From: Jeater, Catherine Catherine.Jeater@southwark.gov.uk
Subject: RE: 21/EQ/0042_Pre-Application Advice Report
Date: 18 May 2021 at 14:24
To: Rebekah Lindsay rebekah@granit.co.uk
Cc: Robert Wilson rmcw@granit.co.uk

Re. 29 Champion Grove, SE5 8BN

We are currently preparing the LB application following your Pre-App report. The report asked for additional information on the LGF chimney and masonry partition; both of which were submitted on 13/04; please can you confirm if you received these and if they are sufficient in supporting our case?

Drawing No. **2020/P/100**
 Drawing **Proposed Lower Ground Plan**
 Purpose **FOR PLANNING**

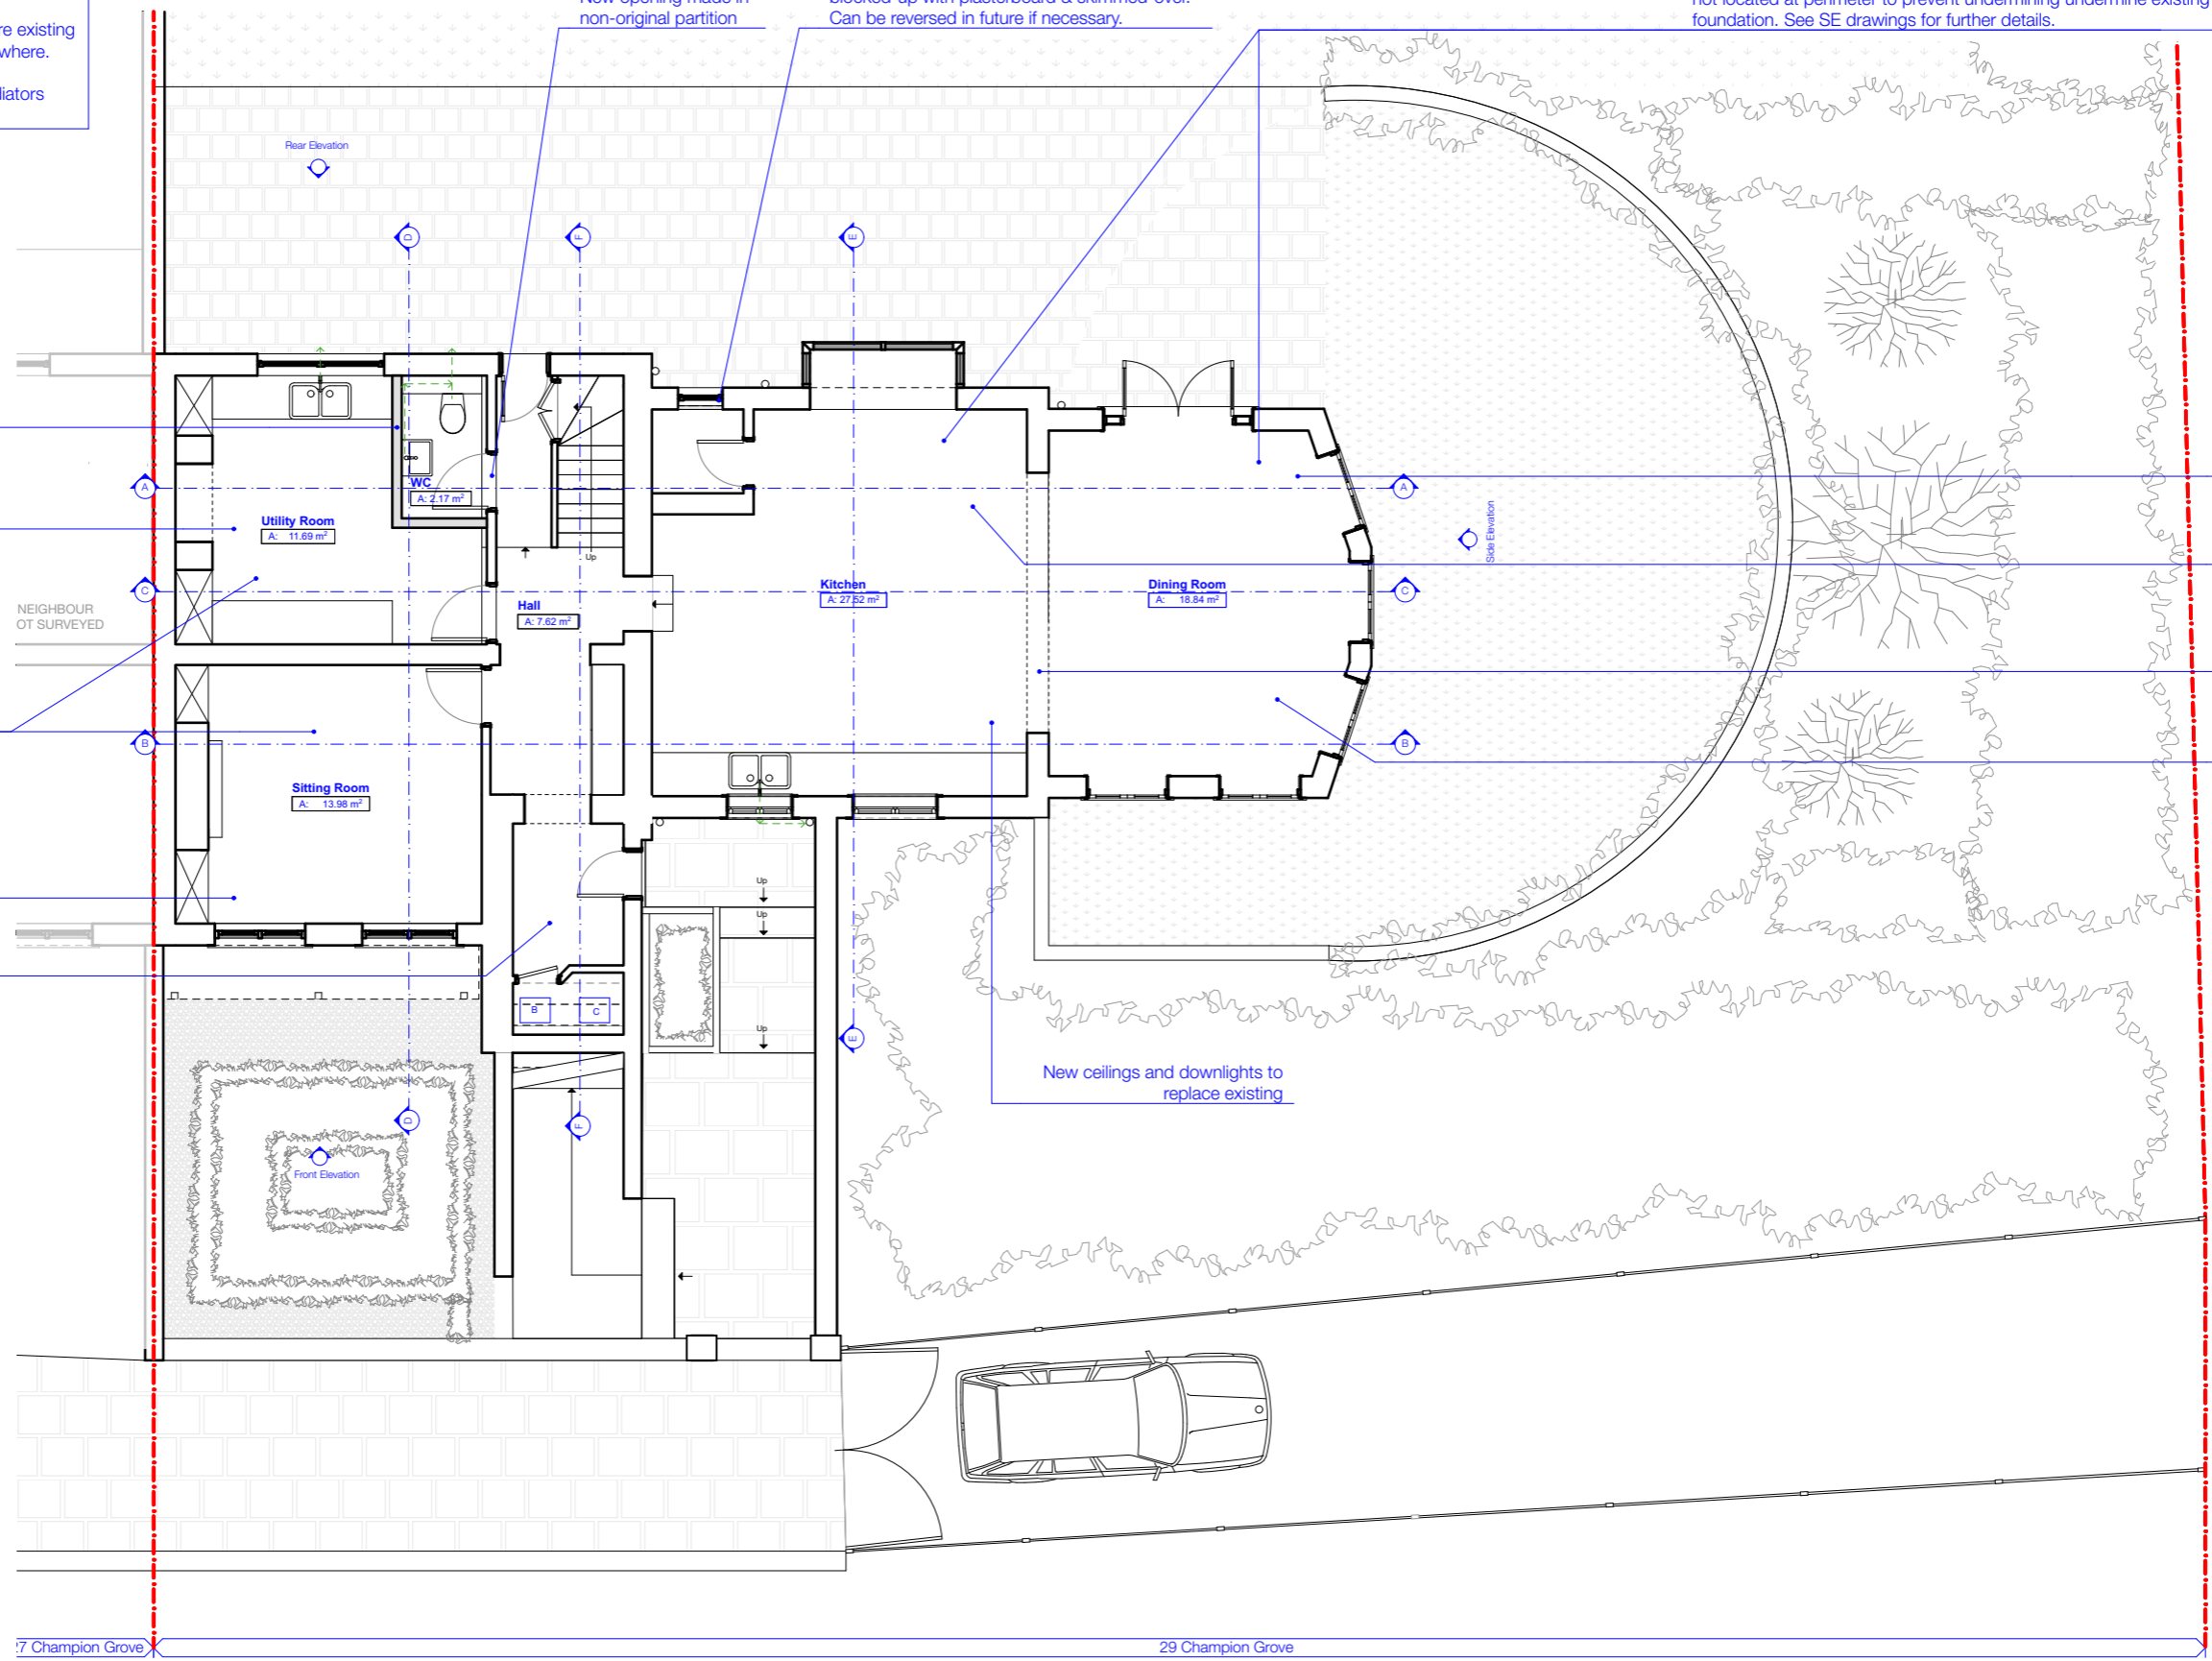
Thank you for your email. I'm sorry I missed the email you sent on the 13th April – I have now reviewed and can confirm with regards to the chimney stack it has been much altered and therefore doesn't relate well to the room – it could be removed with consent and the information sent regarding the strip out.

The basement utility room cloakroom could also be accessed via the hallway as the wall in that location is also unlikely to be original. Please include the additional information with the application.
